20 June 2016

**Remediation, Restoration and Adaptive Re-Use of Campbell's Stores  
Amended DA/EIS**

Drawing Title  
**BAY 12 ROOF PLAN**  
 JPW Project Number  
**12006**  
 Drawing Status  
**EA**  
 Drawing Number  
**EA-A-1006**  
 Revision  
**B**

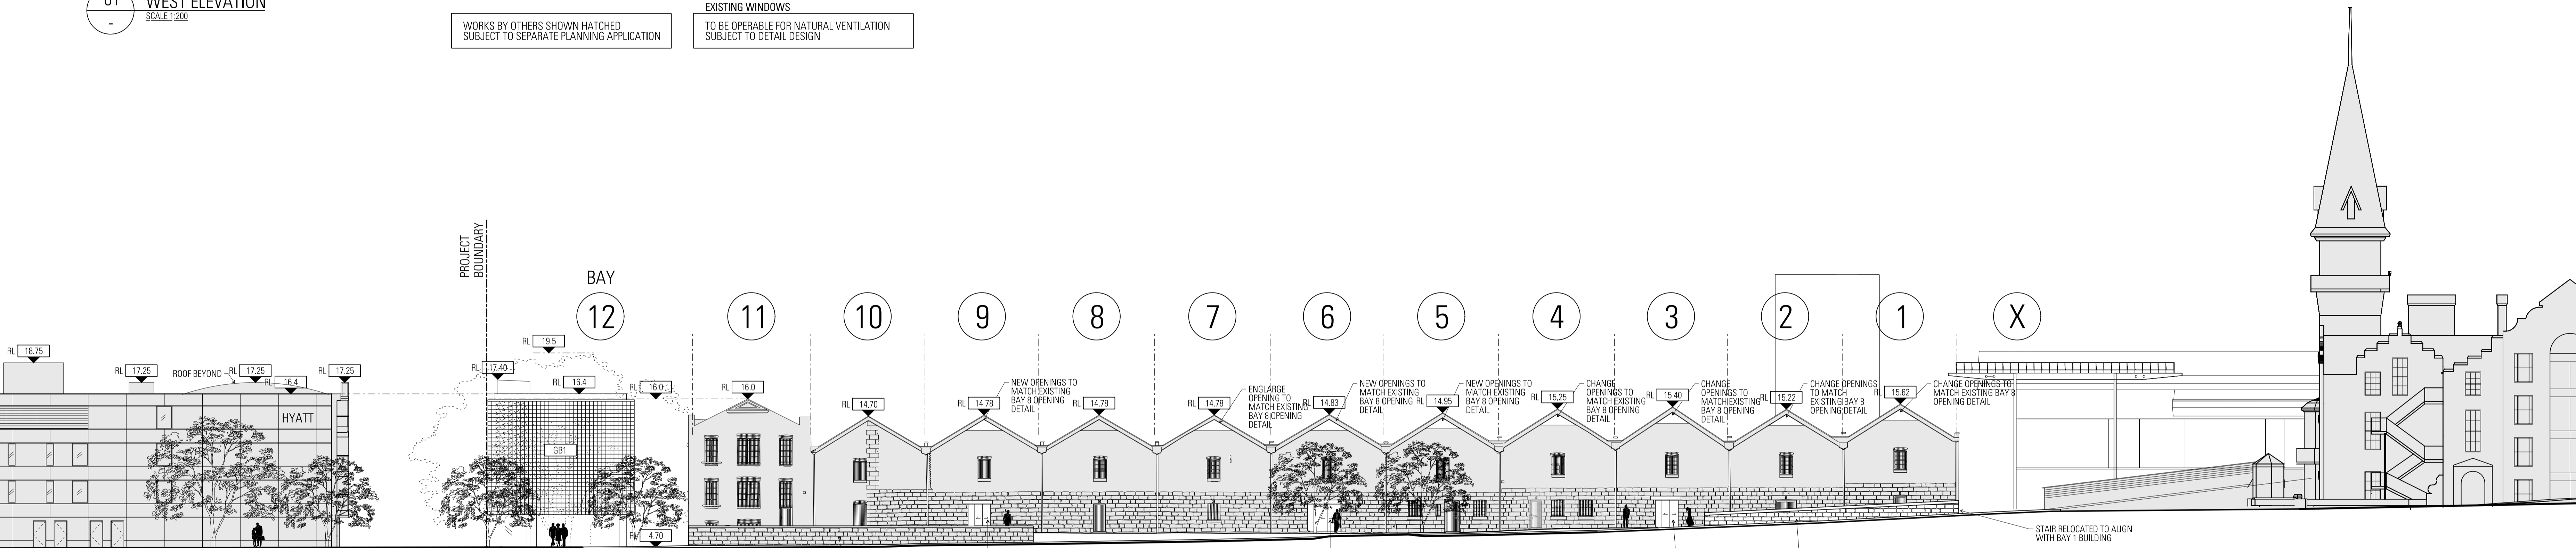
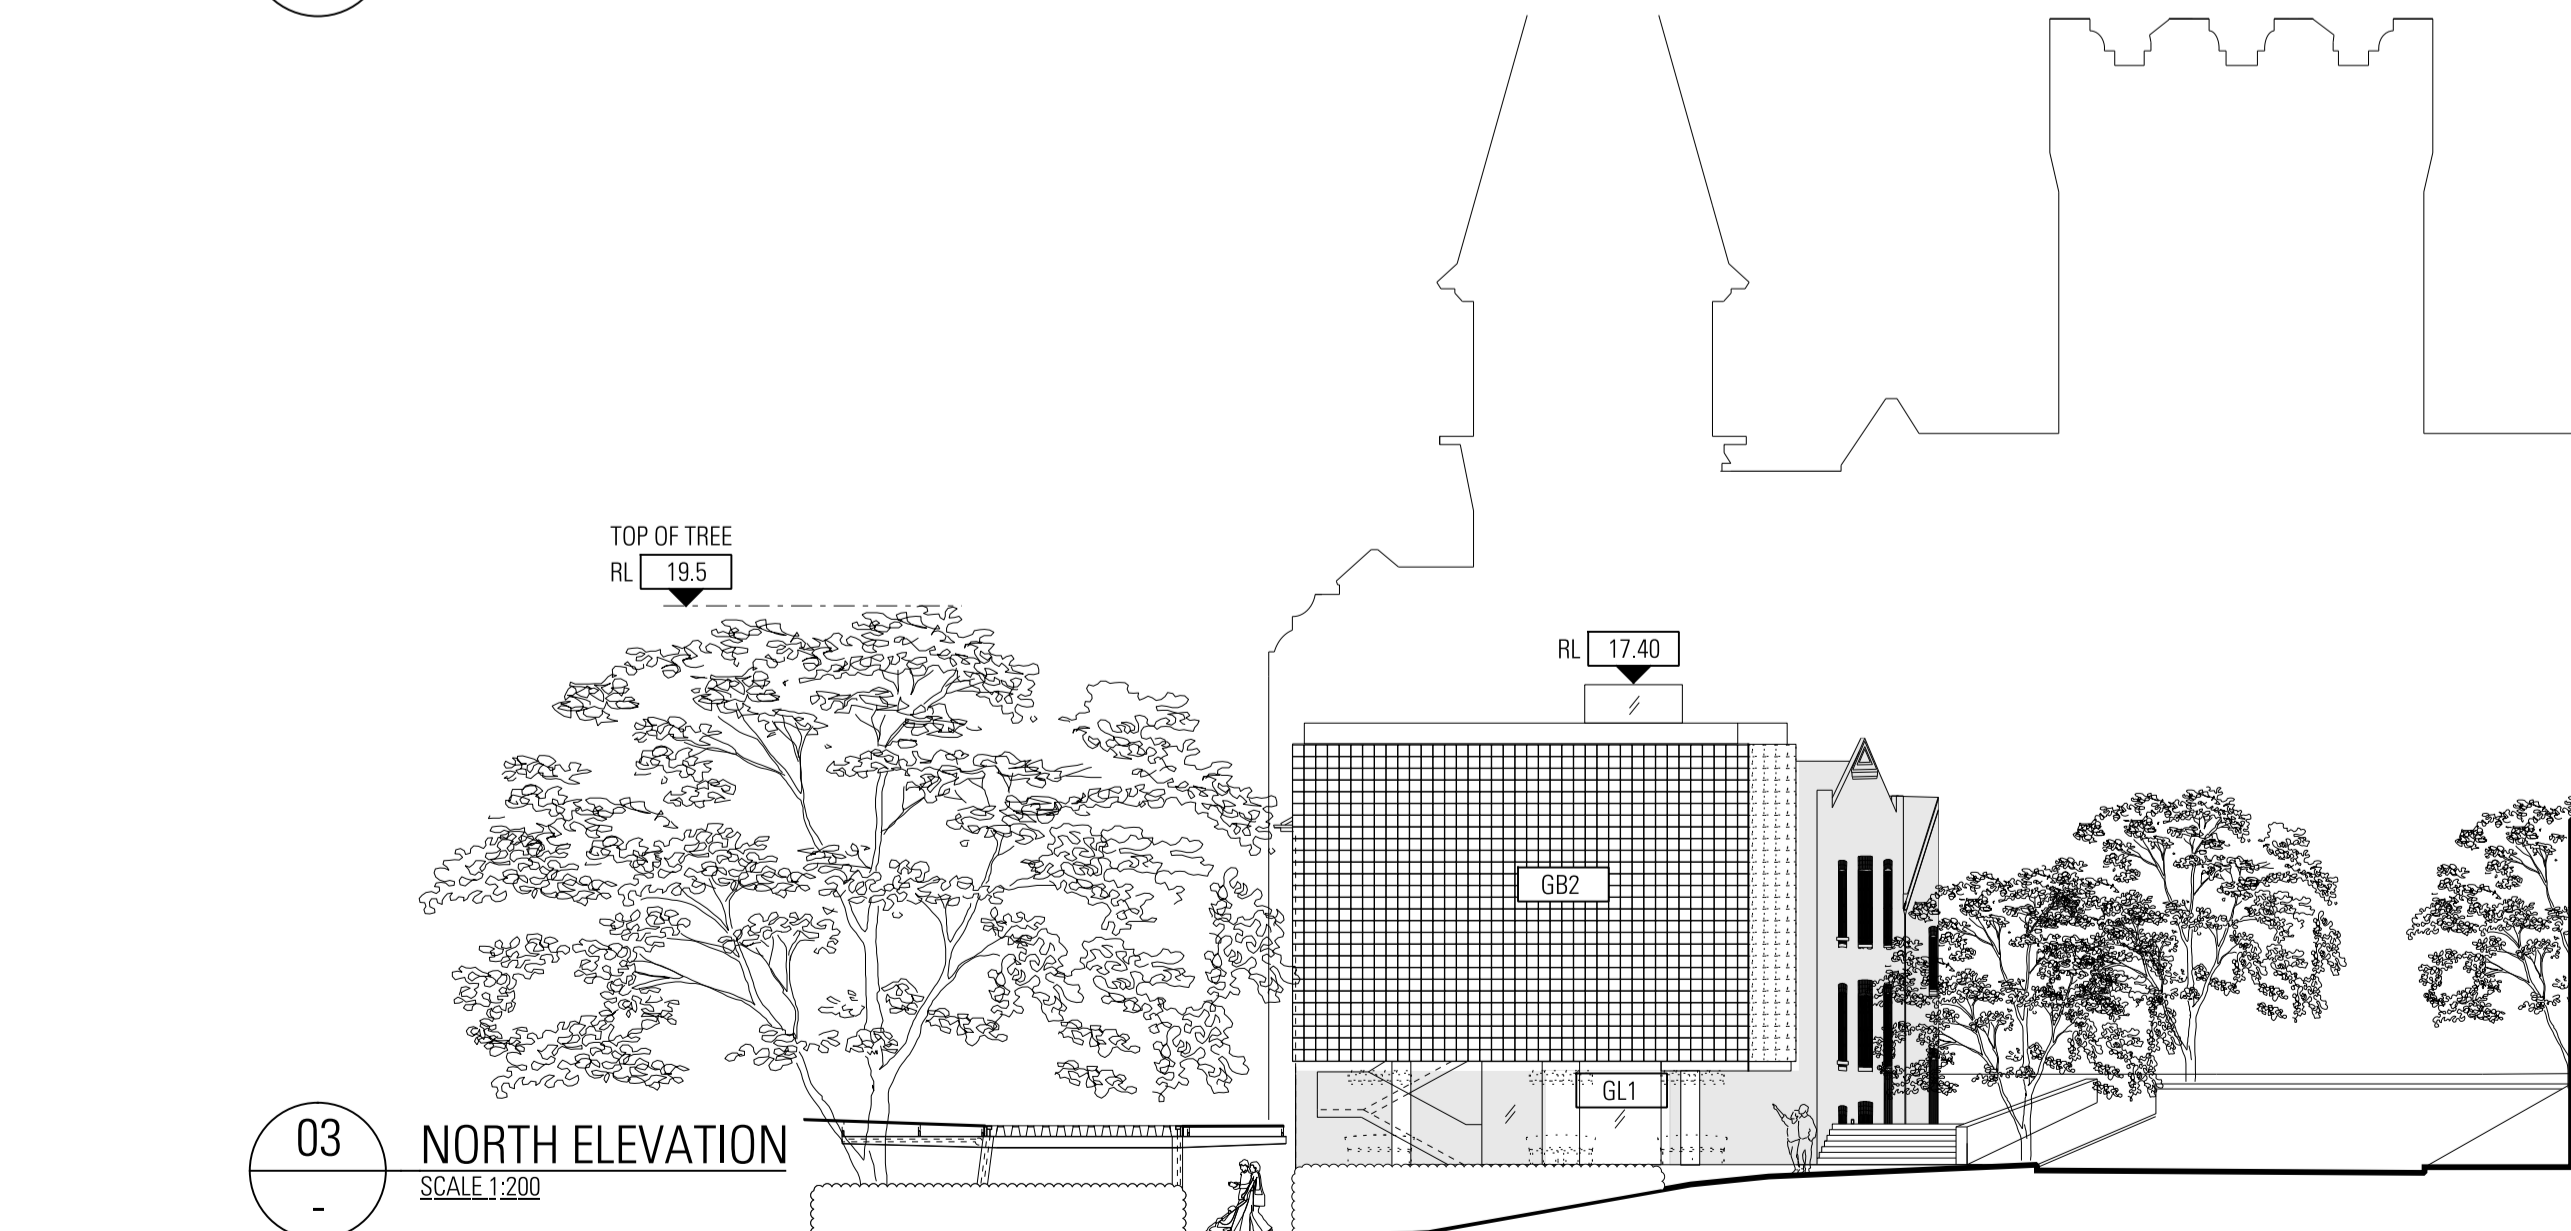
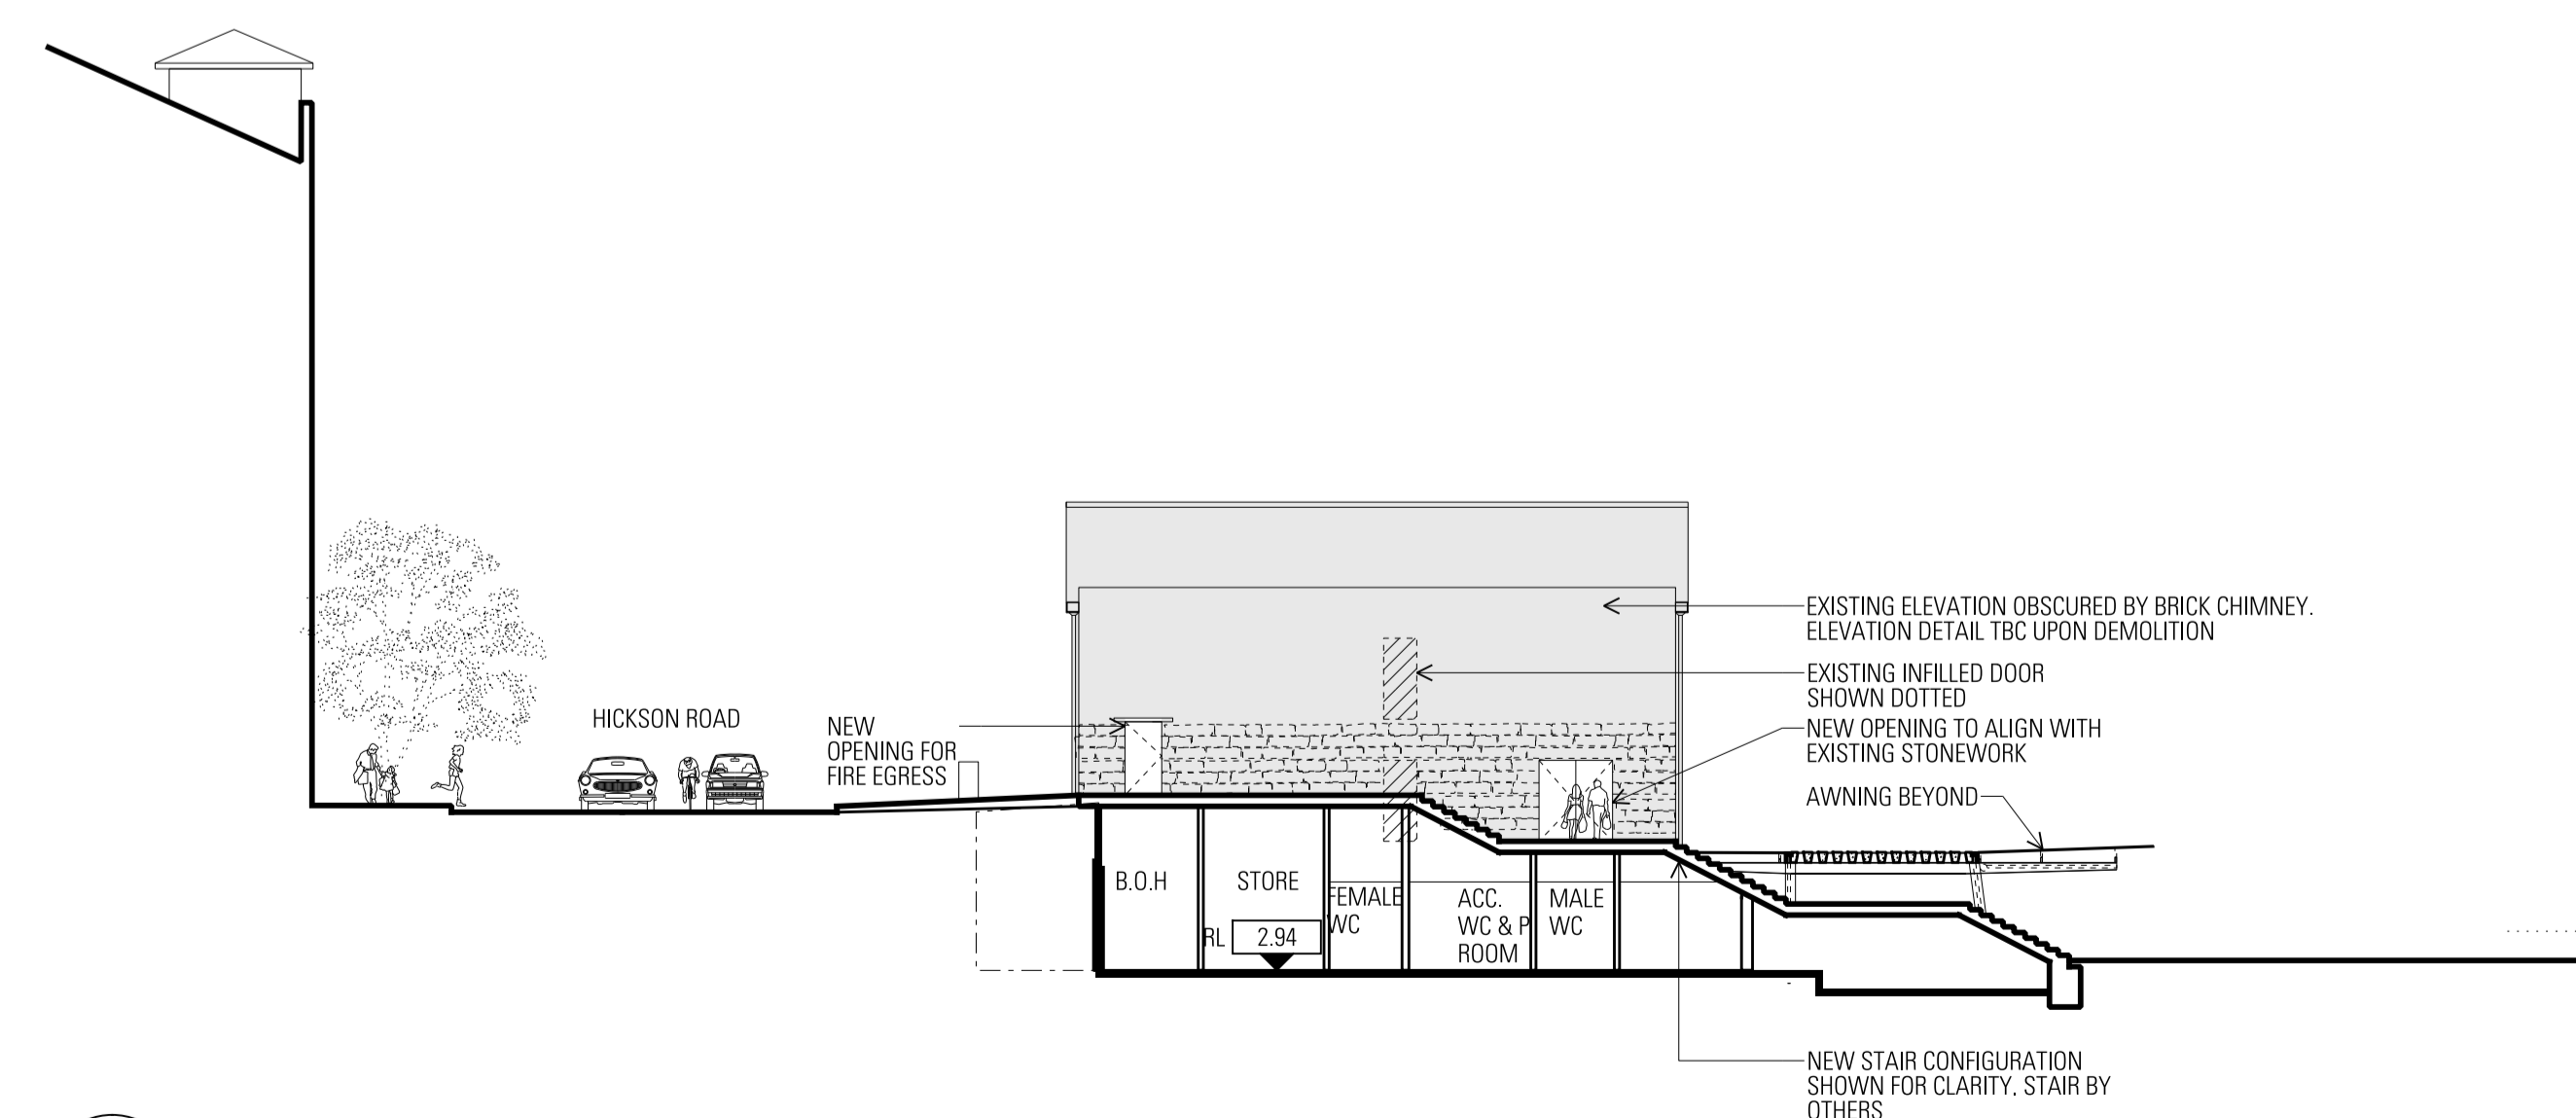
Proposed Bay 12 under the amended proposal would still block views of the stores from the north-west on Hickson Road and reduce integration between Hickson Road and the harbour. The proposed building has no aesthetic or functional connection to the Campbell's Stores and is an unnecessary addition to the proposal.

***Could you please refuse the inclusion of a new building at Bay 12 as part of the proposed Campbell's Stores restoration?***
